EPC STORMWATER REVIEW COMMENTS
IN ORANGE BOXES WITH BLACK TEXT

VOLLMER ROAD (NORTH)

GRADING AND EROSION CONTROL PLANS

FEBRUARY 2023

VOLLMER ROAD
STA 43+00 TO STA 53+00

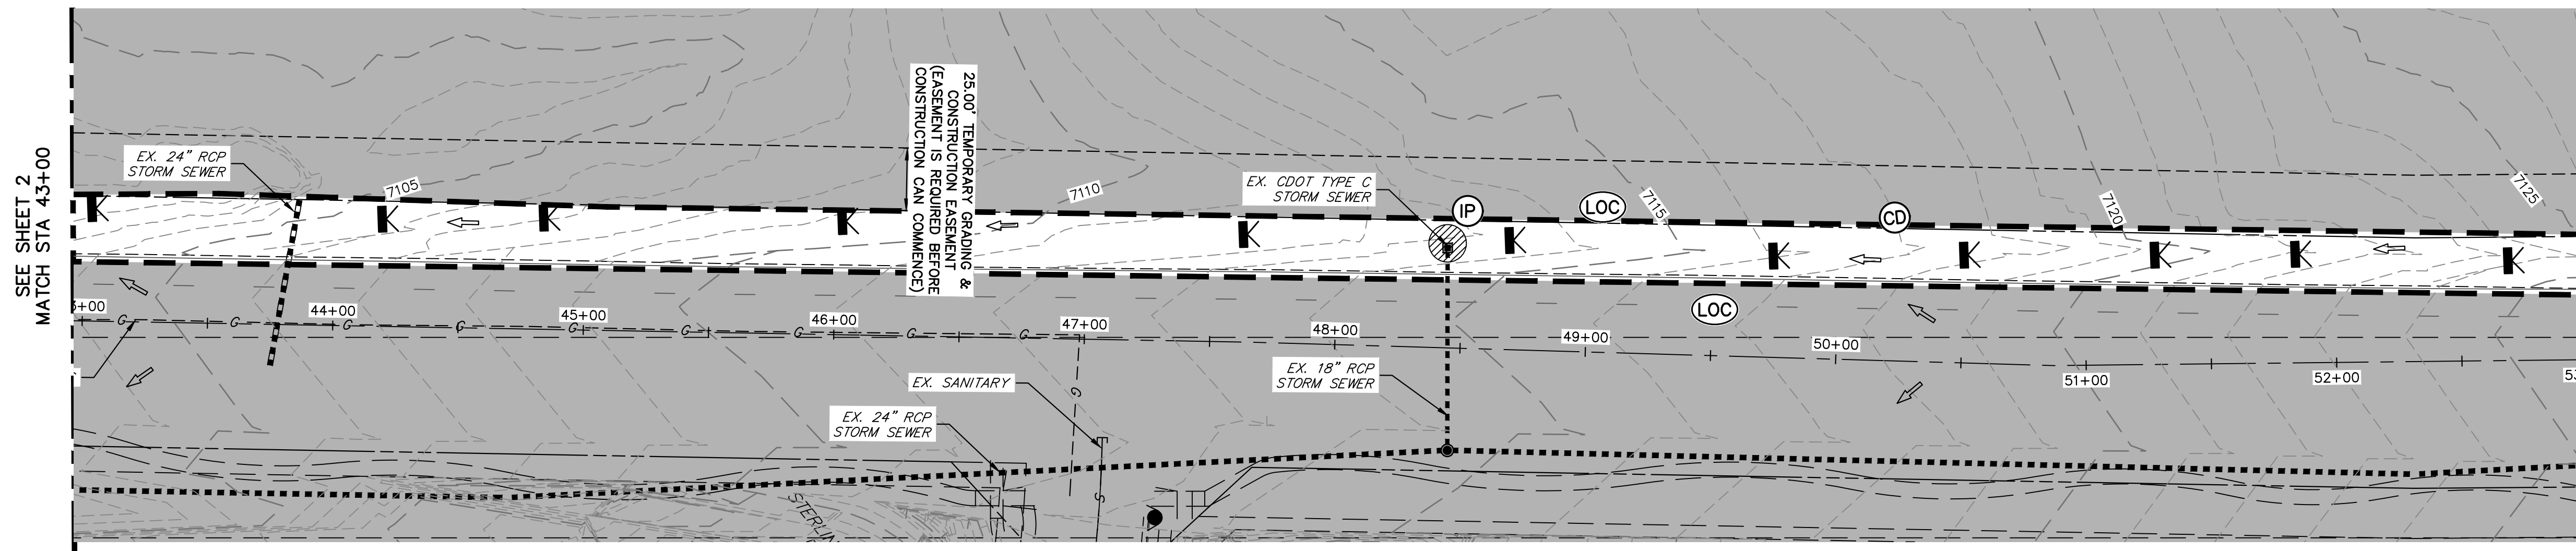
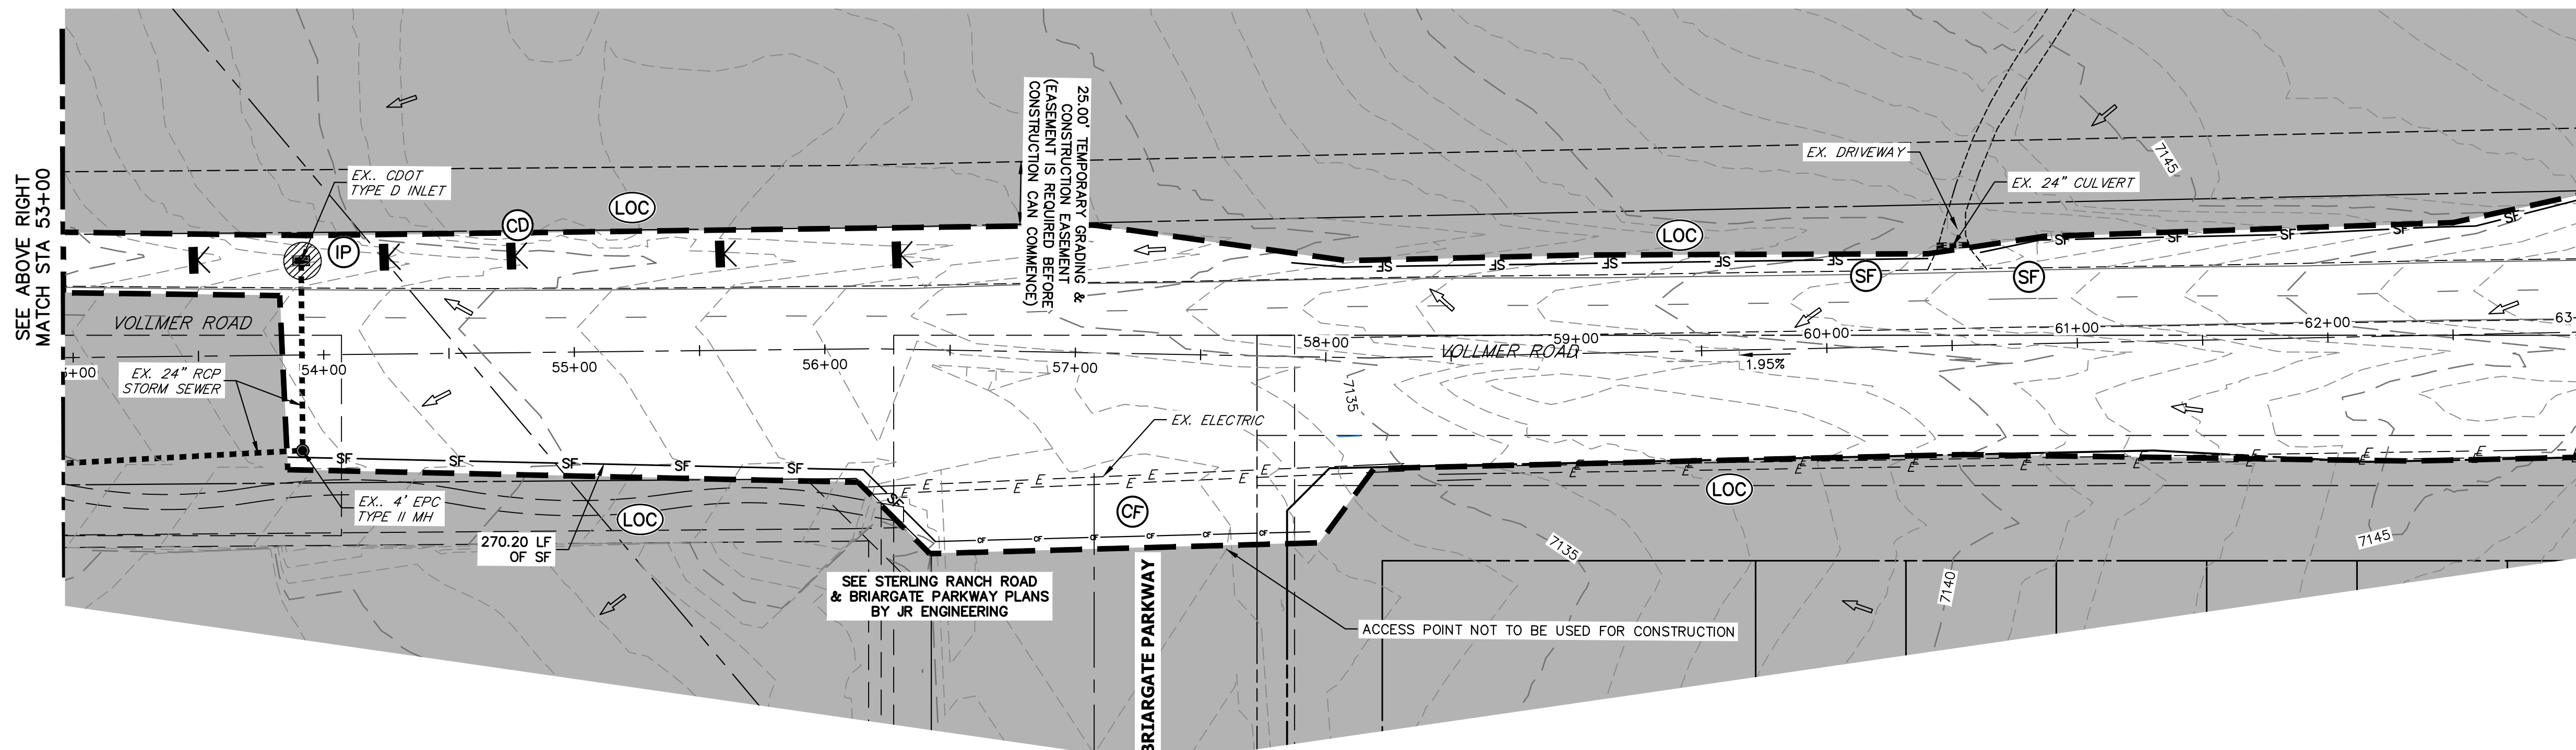
Label all existing facilities. Typical comment for all sheets.
